**Our Ref: BR/17/14/
Your Ref:**

Application for Planning Permission for Works or Extension to a Dwelling

Development Proposed single storey rear extension with internal alterations to the dwelling.

Location 17 Longford Road Bognor Regis

BLOCK PLAN

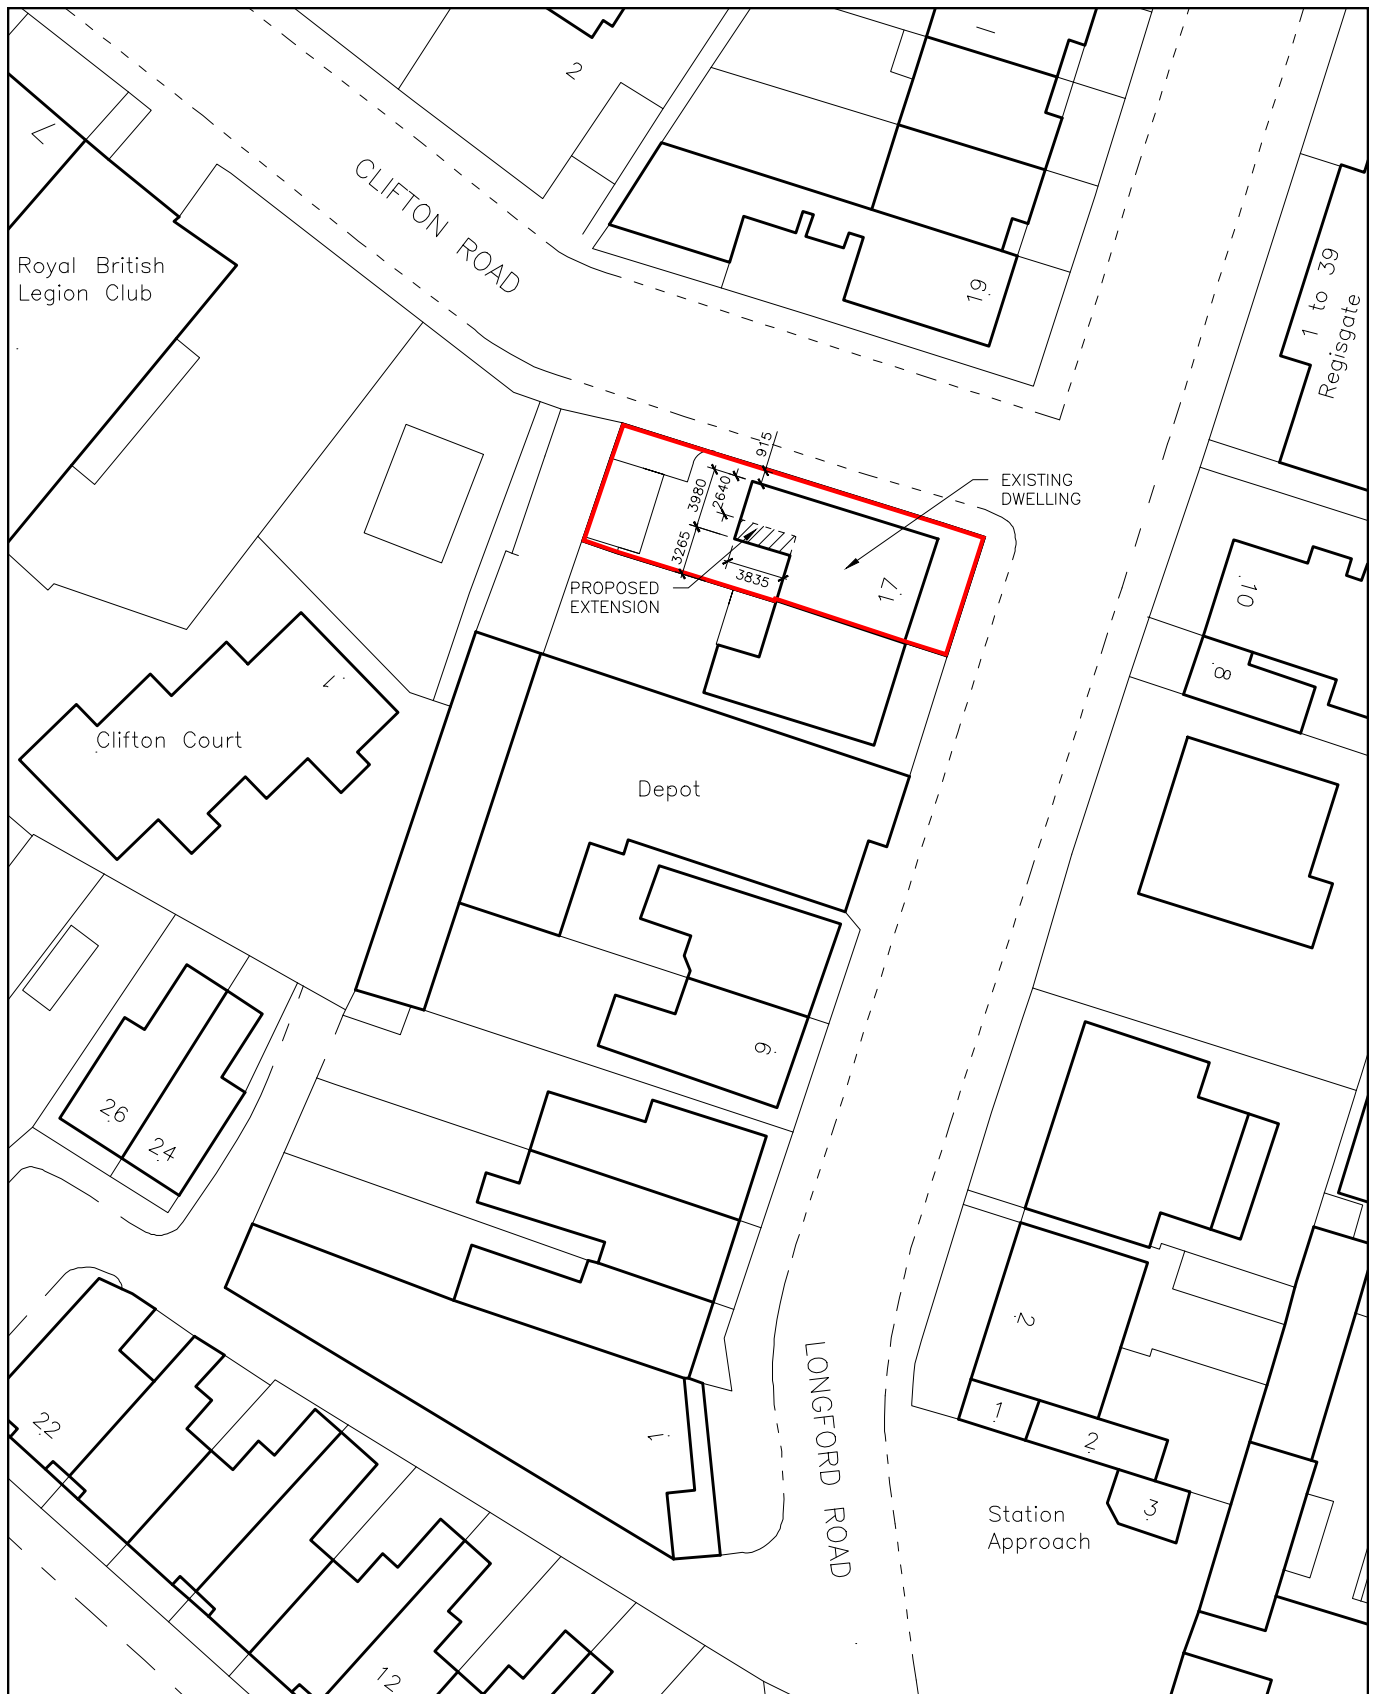
Block Plan

Please submit 1 electronic or 3 paper copies of a revised block/site plan at a scale of 1:500 or 1:200, to include site dimensions from the dwelling to the site boundaries. Further details of what must be included on the plan can be found in the National Validation Requirements.
